Submission for Job: #7172 Hume Coal Project

Site: #3137 Hume Coal Mine

## **Submission by the Berrima Residents Association Hume Coal EIS June 2017**

Noise catchment areas and noise monitoring locations

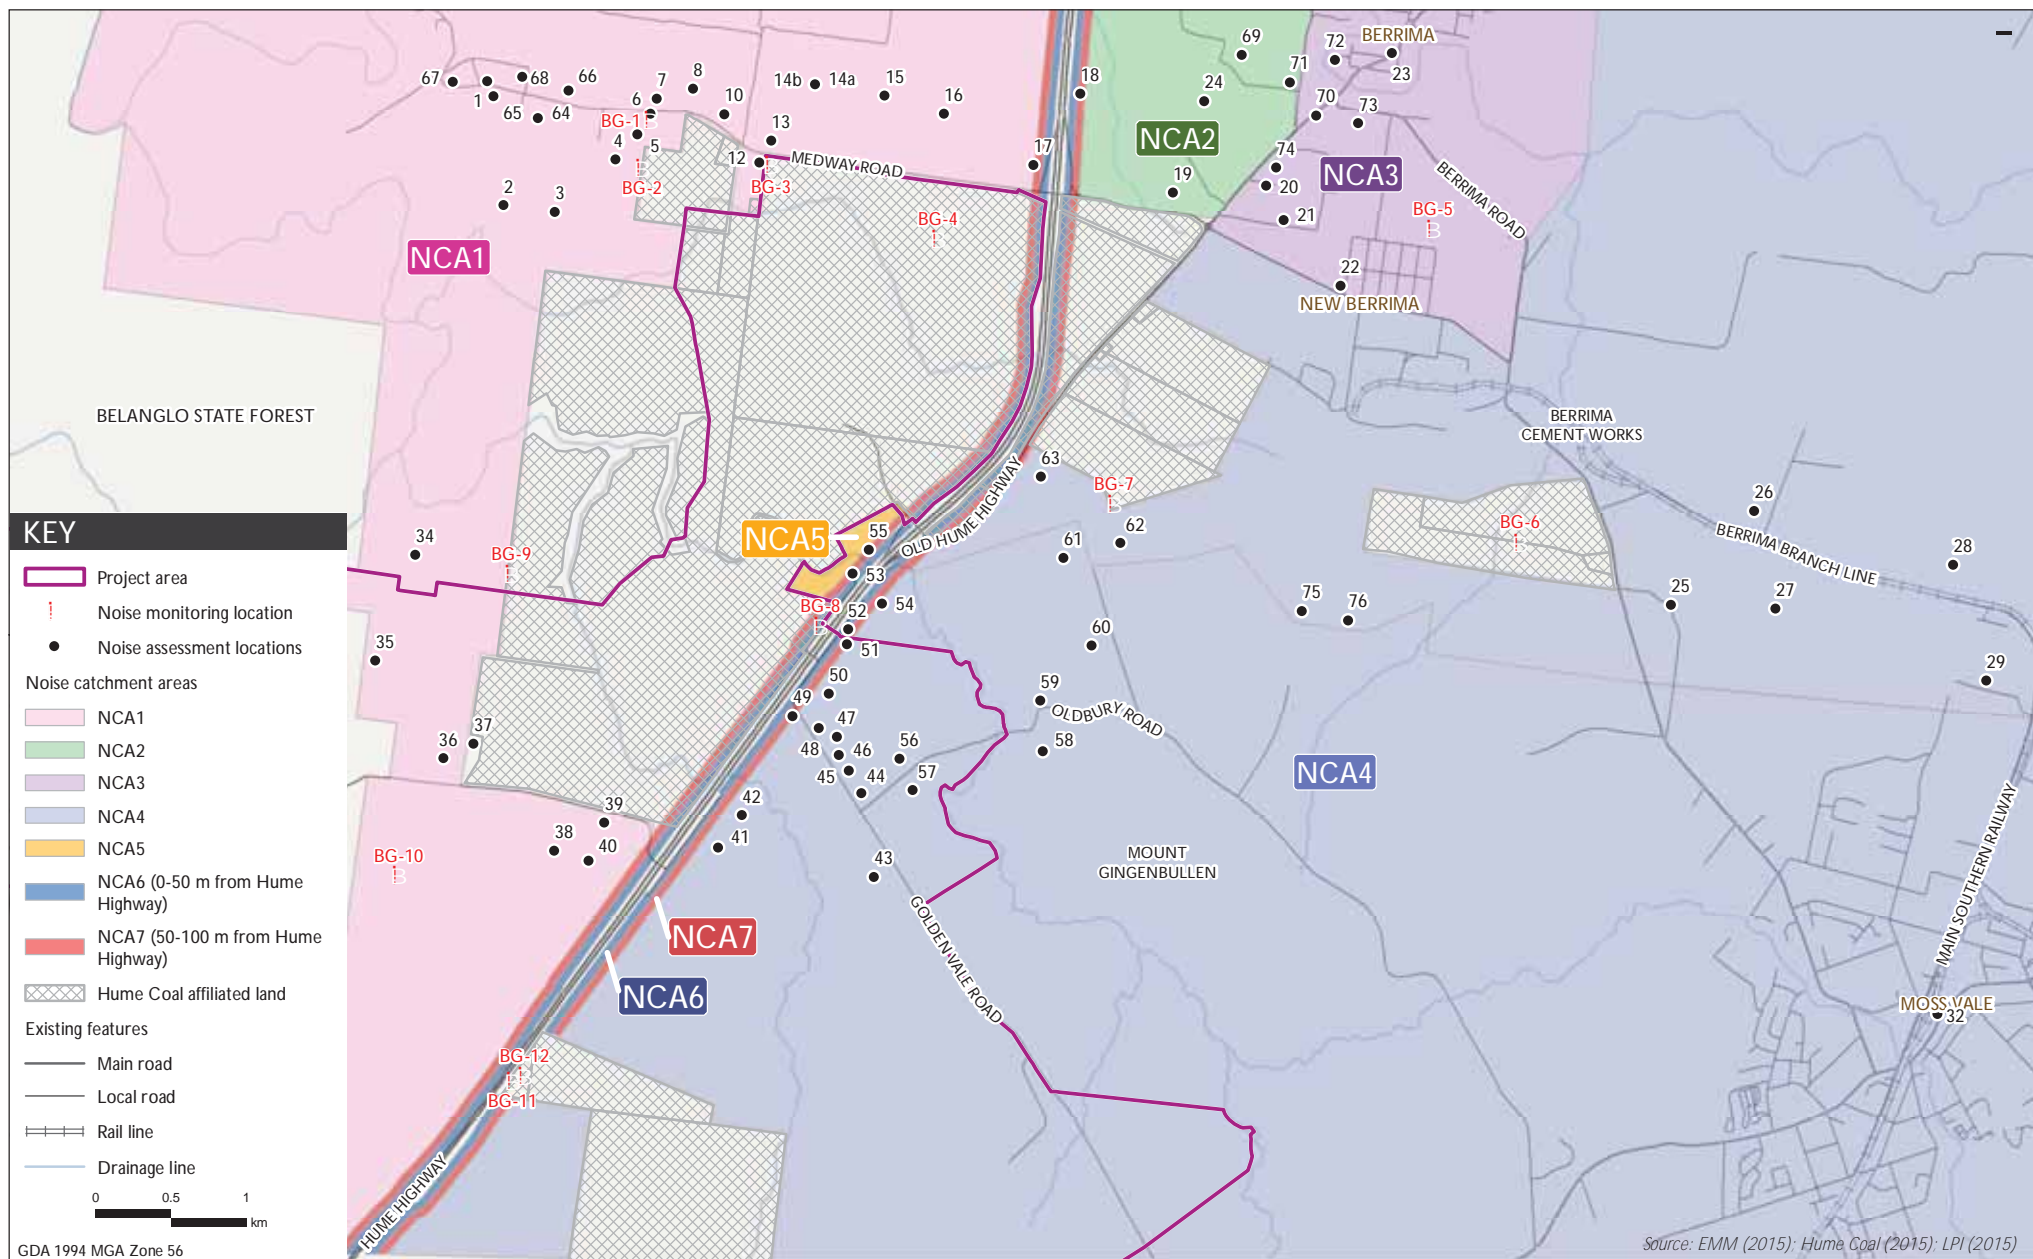
- no station was installed in Berrima ( see Fig 11.2, p.290).
- no station was installed on the Old Hume Highway, near the proposed rail maintenance siding, south of the Medway Road round-about
- the only weather station near local centres of population centres, Station BG-5, is located in bushland to the east of New Berrima. This location would not pick up background from traffic on the:
  - Old Hume Highway passing through Berrima
  - Noise from grinding at the Boral cement works heard in Berrima
- The strategic decision by Hume Coal to locate the BG-5 station in such a remote location means that estimates of the cumulative impacts of noise on residents from the Project, including from the rail transport and siding operations, will be underestimated
  - Accordingly, estimates of the number of properties expected to experience noise impacts is underestimated and unreliable
